DATE: December 10, 2019  
TO: Kari Parsons, PCD-Project Manager  
FROM: Keith Cerjan – Project Designer  
SUBJECT: Response to “**SF-19-006– Midtown Collection at Hannah Ridge Filing 2 Second Submittal**”, dated September 9, 2019

Please find below the responses to the aforementioned second comment letter. Responses to review comments are shown in **BOLD** below the comment.

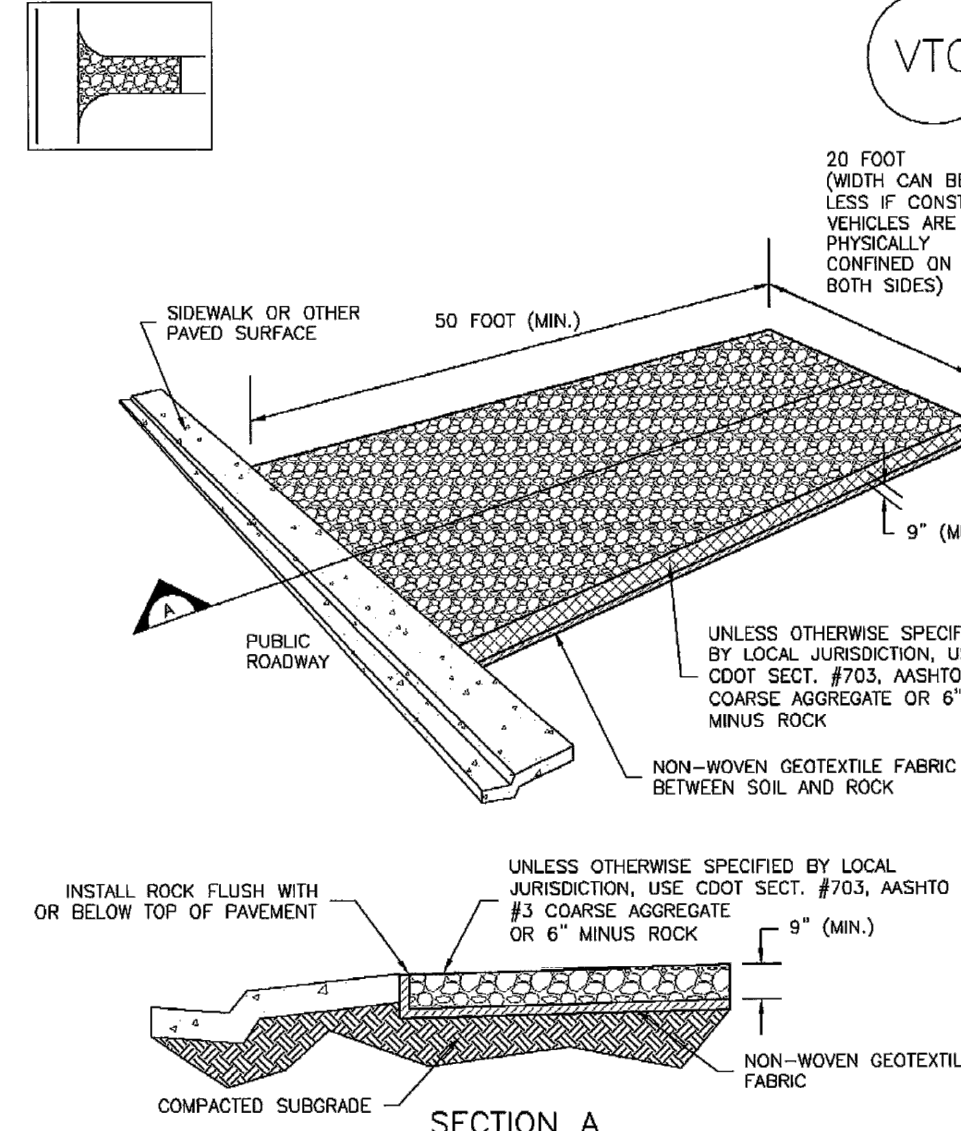
1. **Resolved.**
2. Provide street and pedestrian signage as appropriate for pedestrians along and crossing Constitution. Please discuss with Staff. **Unresolved.**  
**RESPONSE: Per meeting with County, crossing of Constitution is only viable further west away from the site until the signal is warranted and installed.**
3. **Resolved.**
4. **Resolved.**  
Show and label permanent BMP maintenance access roads on the plans. **Unresolved, See redlined plans.**  
**RESPONSE: No permanent BMPS within Filing No. 1. This was address in Filing No. 1.**
